**Application for Planning Permission for Works or Extension to a Dwelling**

**Development:** Rear dormer  
**Location:** Elms Paddock Horsemere Green Lane Climping BN17 5QZ

Drawing Title Floor Plans as existing

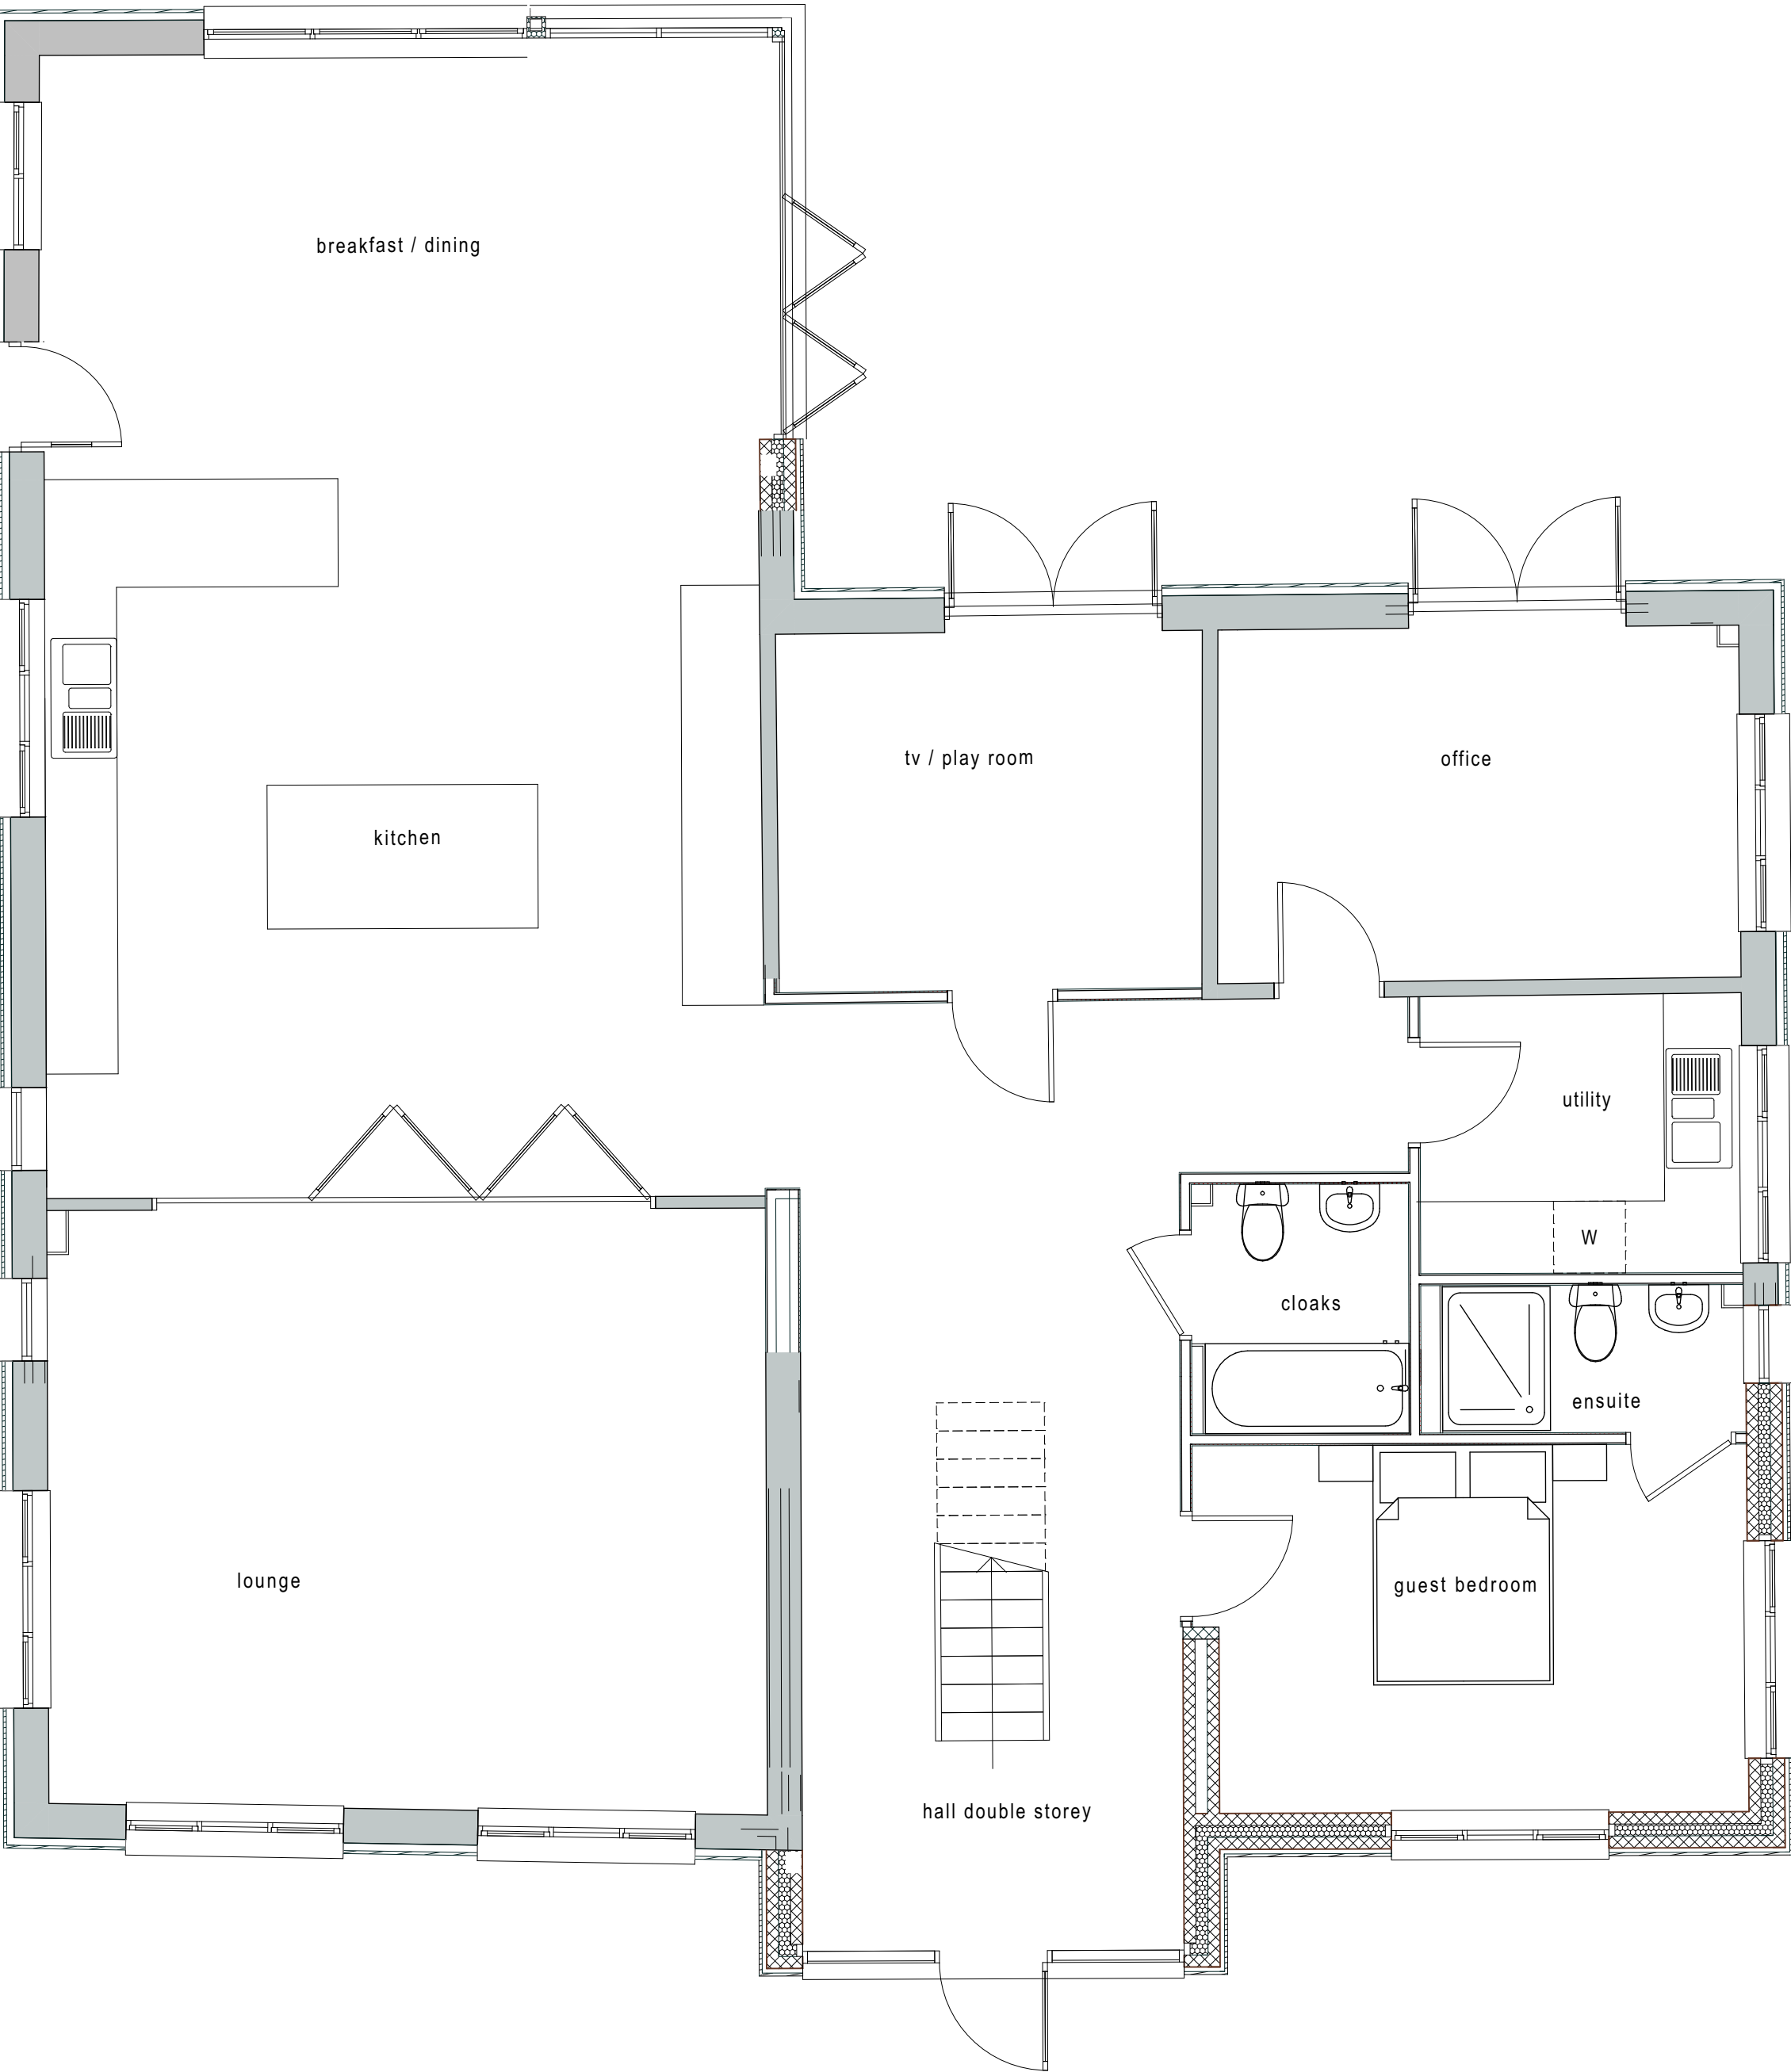
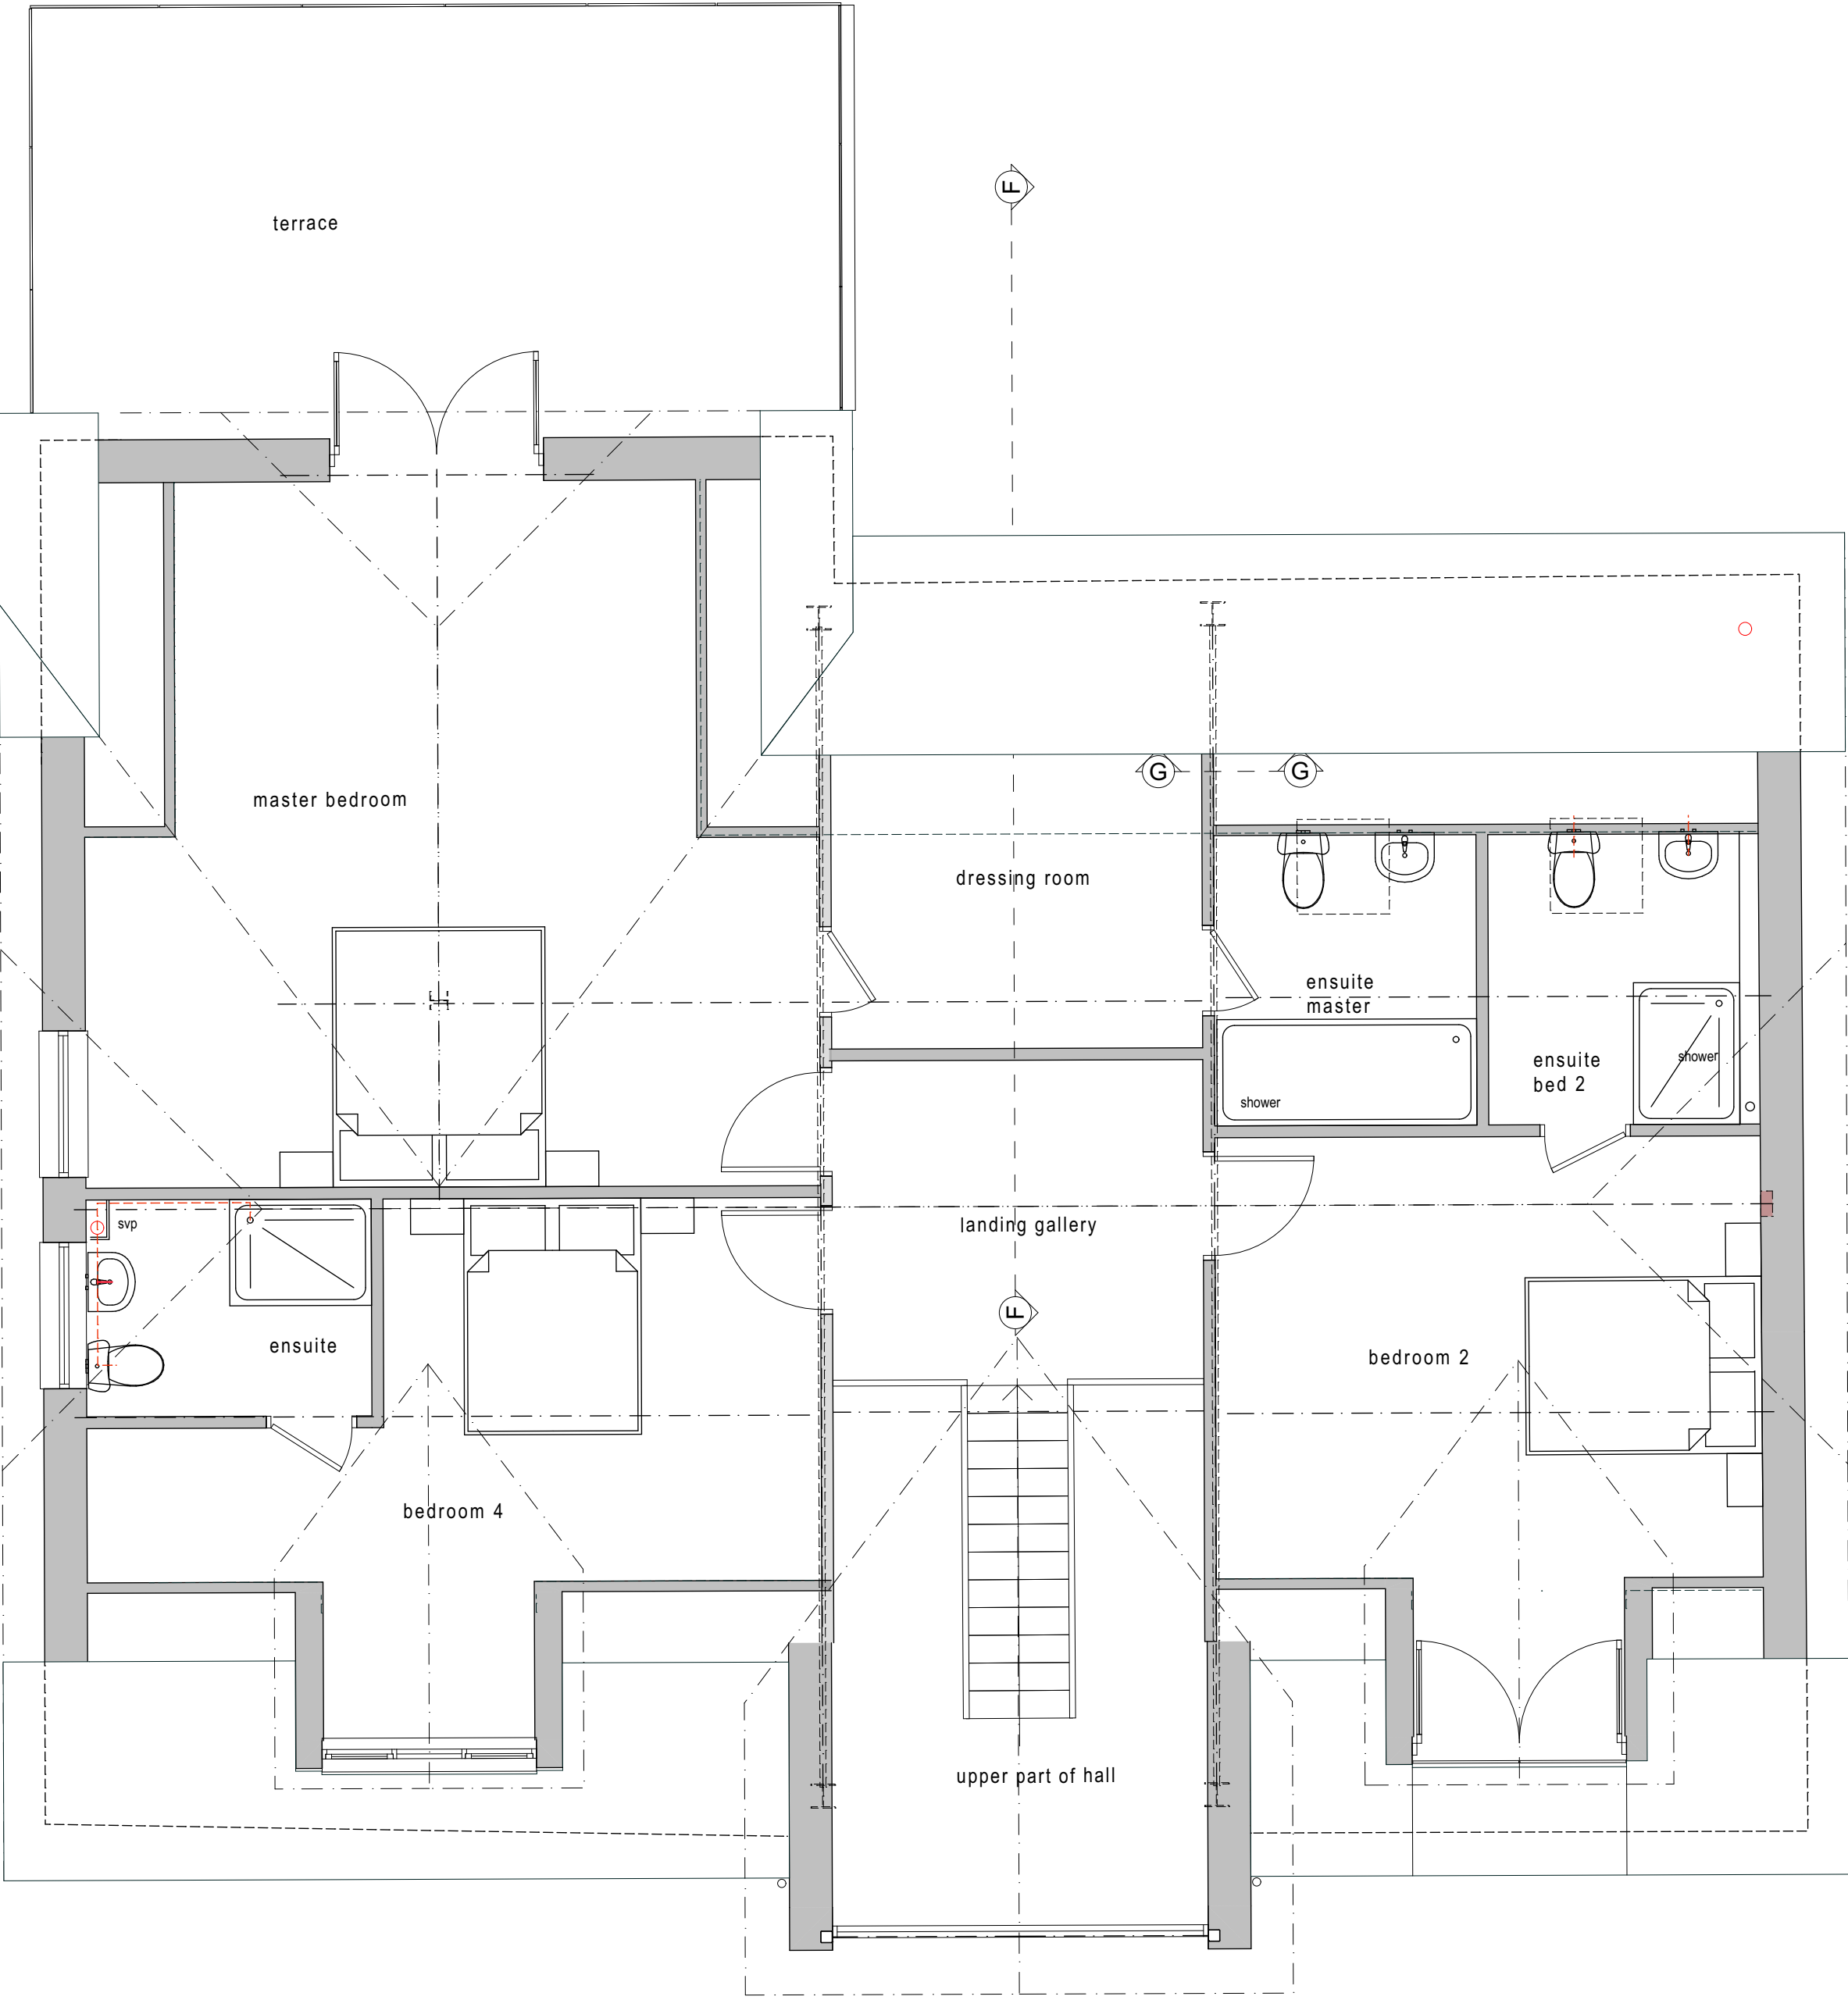
The existing floor plans contain annotations of the proposed work. Please remove these from the existing plans.
